**WELWYN HATFIELD BOROUGH COUNCIL
EXECUTIVE DIRECTOR - PLANNING, PUBLIC PROTECTION AND GOVERNANCE**

Application No: 6/2019/2571/VAR
Location: 101 Brookmans Avenue, Brookmans Park, Hatfield, AL9 7QG
Proposal: Variation of condition 11 (approved drawings) on planning permission 6/2019/0434/FULL
Officer: Mr David Elmore
Recommendation: Granted

6/2019/2571/VAR

Drawing Title  
HOUSE 4

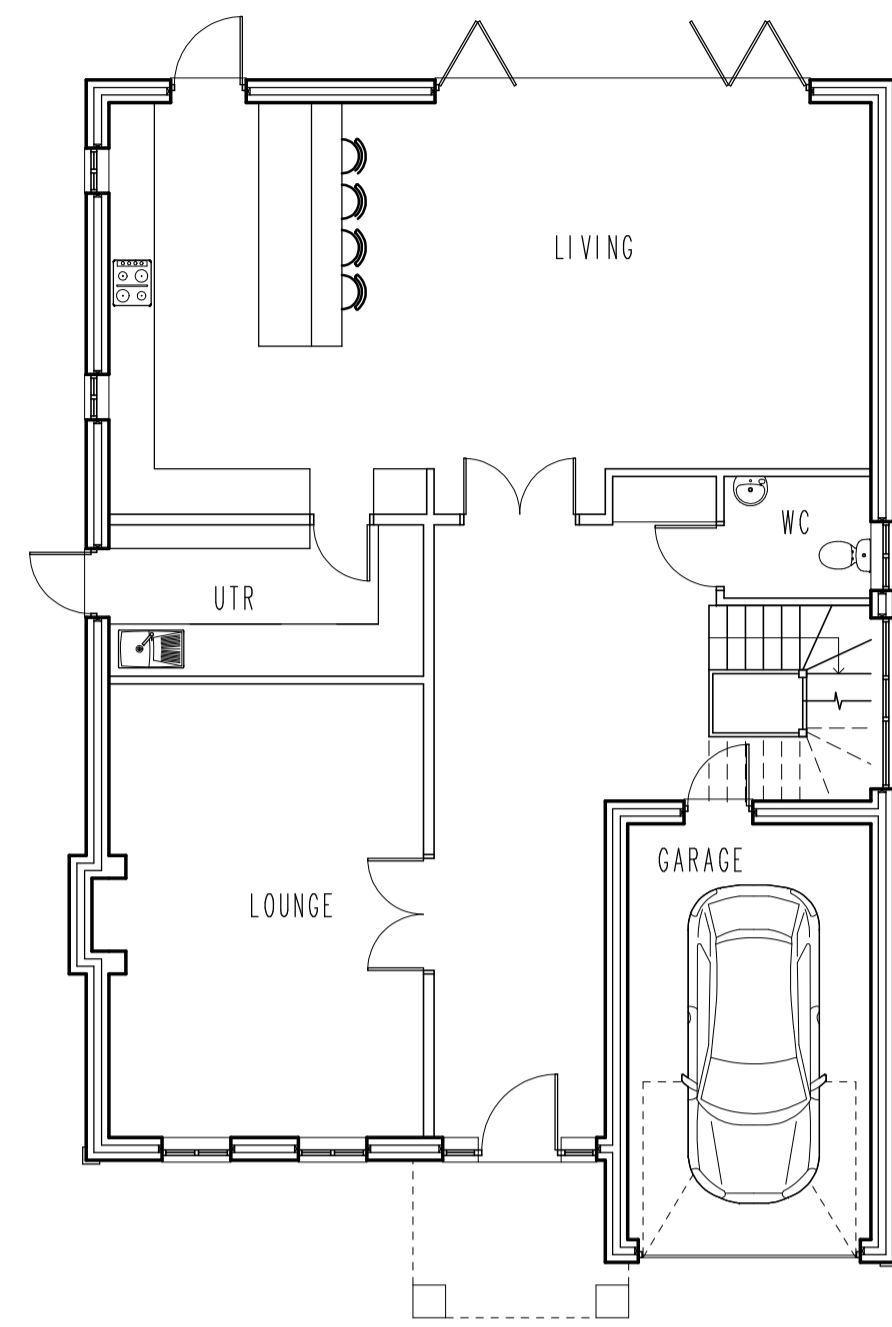
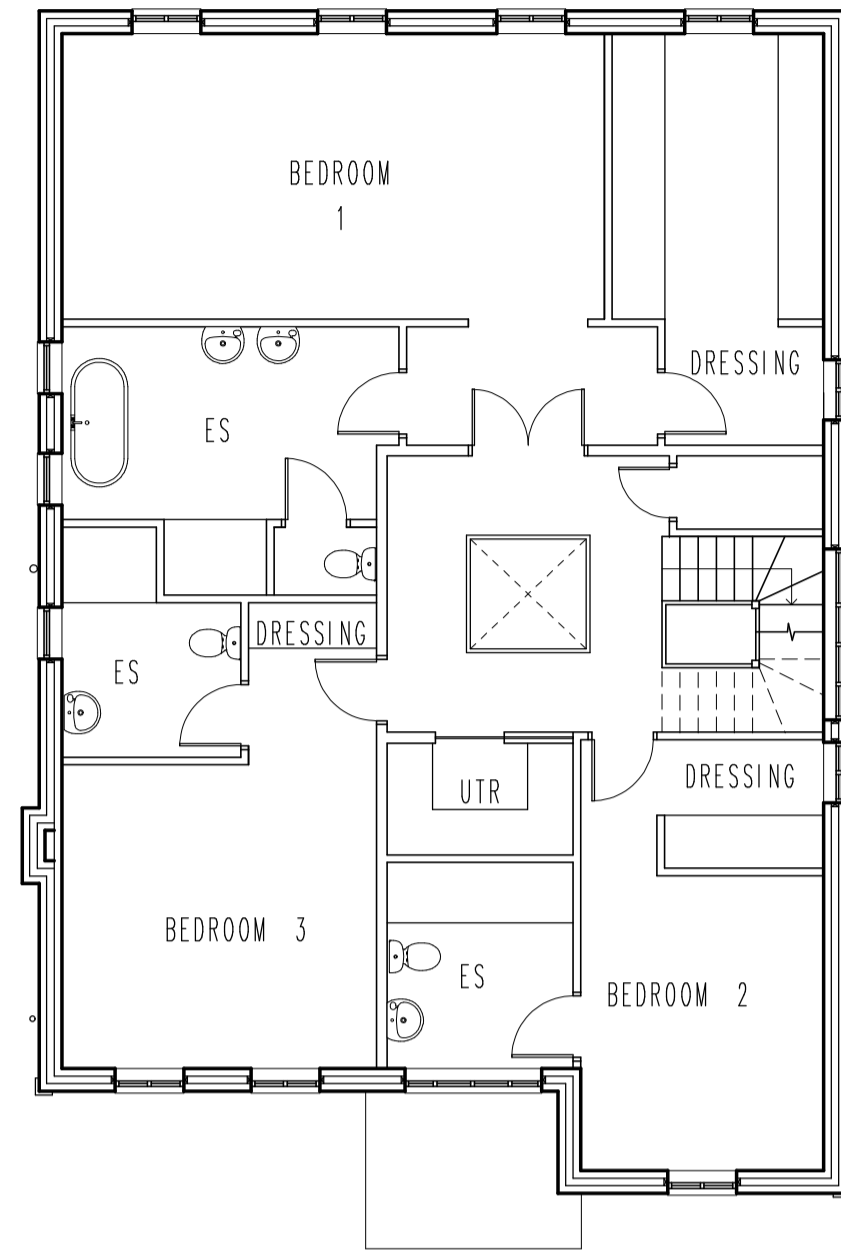
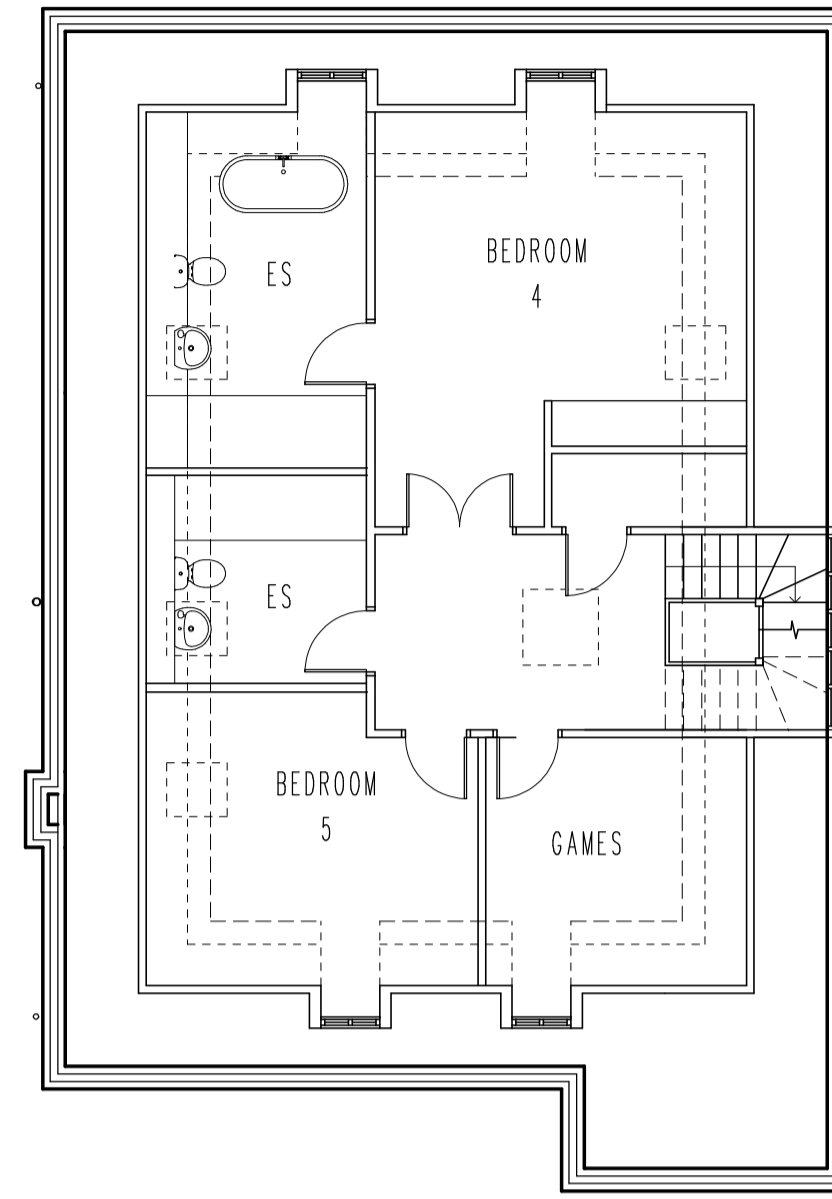
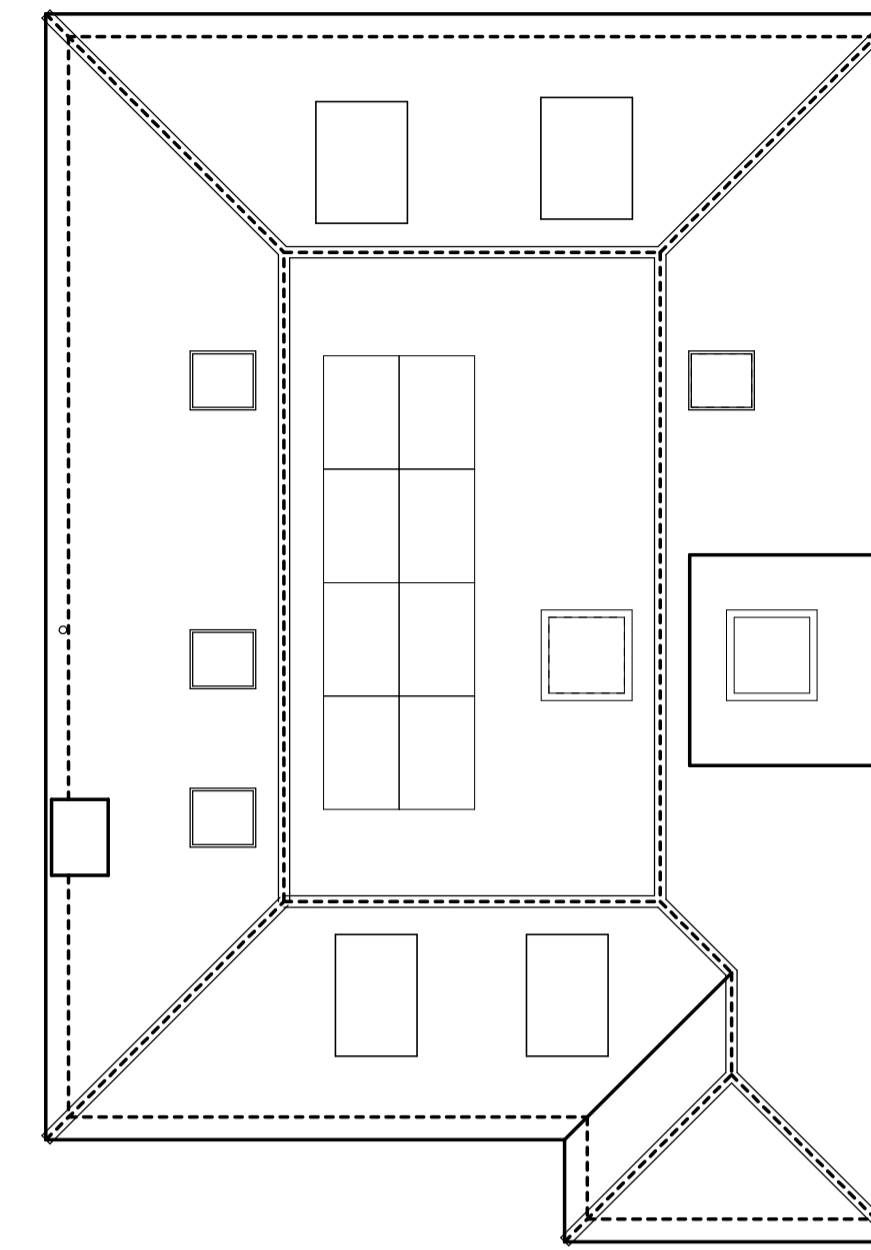
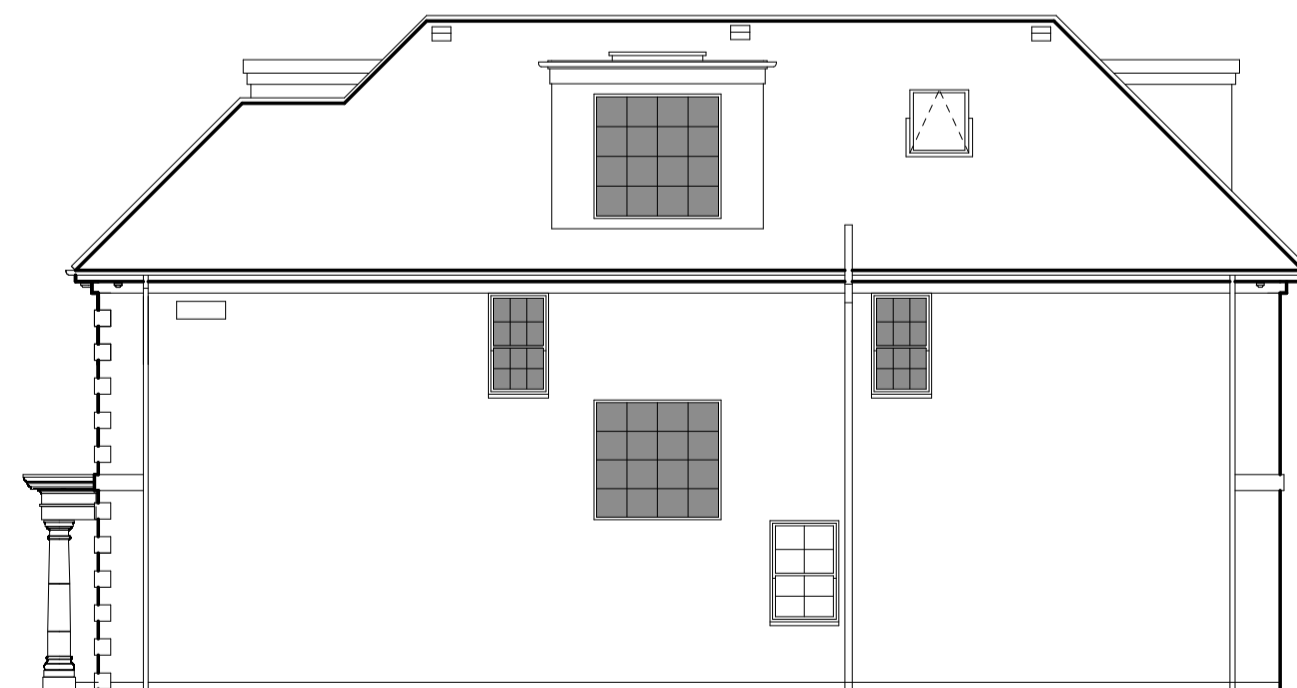
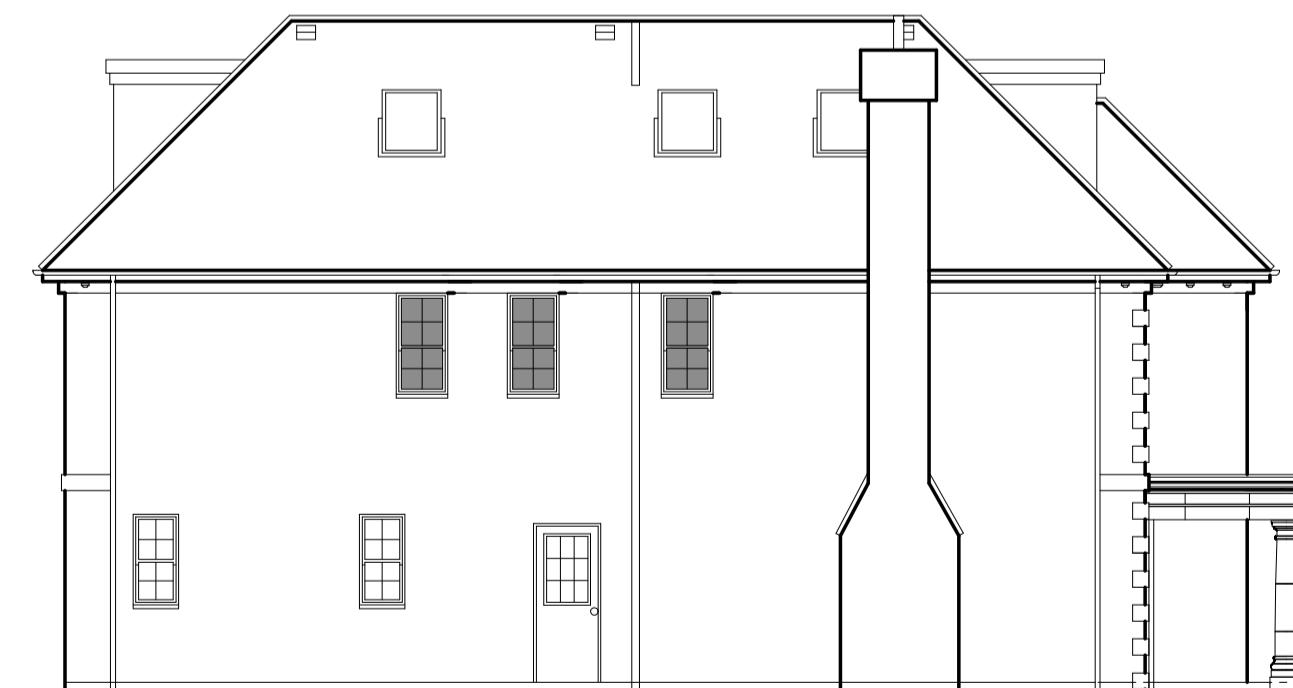
Context	
Site and Application description	<p>This application seeks a variation to condition 11 (approved plans) of planning permission: 6/2019/0434/FULL. The proposed changes to the approved plans include:</p> <ul style="list-style-type: none"> - Increase in size of side dormer serving staircase of Houses 3, 4 & 5. Width increased by 0.6 metres; - One parking space removed from front driveway of Houses 3, 4 & 5; - Study of Houses 3, 4 & 5 replaced with a garage; and - Fenestrations details of Houses 3, 4 & 5 amended
Constraints (as defined within WHDP 2005)	<p>PAR - PARISH (NORTH MYMMS) Wards - Brookmans Park & Little Heath</p>
Relevant planning history	<p>Application Number: 6/2019/3006/COND Decision: Under consideration Decision Date: Proposal: Submission of details pursuant to condition 2 (crown roof details) and condition 3 (biodiversity and external lighting) on planning permission 6/2019/0434/FULL</p> <p>Application Number: 6/2019/2313/FULL Decision: Under consideration Decision Date: Proposal: Erection of six dwellings following demolition of existing buildings</p> <p>Application Number: 6/2019/2155/COND Decision: Part Approved / Part Refused Decision Date: 24 October 2019 Proposal: Submission of details pursuant to condition 1 (Materials), 2 (Crown Roof) and 3 (Biodiversity and Lighting) on planning permission 6/2019/0434/FULL</p> <p>Application Number: 6/2019/0434/FULL Decision: Granted</p>

<p>Would the development provide / retain sufficient parking?</p> <p><input checked="" type="checkbox"/> Yes <input type="checkbox"/> No</p> <p>Comment: Whilst Houses 3, 4 & 5 would lose a parking space within the front driveway, each of these dwellings would now benefit with an integral garage to serve one car. As such, there would be no net loss of on-site parking provision.</p>
<p>Any other considerations</p> <p><i>Landscaping</i></p> <p>The extension of the driveways reduces a small amount of landscaping by the fronts of plot 3, 4 & 5 and boundary landscaping to Houses 1 & 2 is increased. Such changes are considered minor. An acceptable landscaping layout would remain.</p> <p><i>Re-imposition of remaining conditions subject to planning permission 6/2019/0434/FULL</i></p> <p>A successful application to amend condition 11 would result in the issue of what would be in effect a new planning permission, sitting alongside the original permission. To assist with clarity decision notices for the grant of planning permission under section 73 should also repeat the relevant conditions from the original planning permission, unless they have already been discharged.</p> <p>Condition 1 (external materials) of planning permission 6/2019/0434/FULL has been discharged under application 6/2019/2155/COND. The approved external materials would be listed in a varied condition if this section 73 application were to be approved.</p> <p>All other conditions of planning permission 6/2019/0434/FULL remain relevant and would be re-imposed if this section 73 application were to be approved.</p>
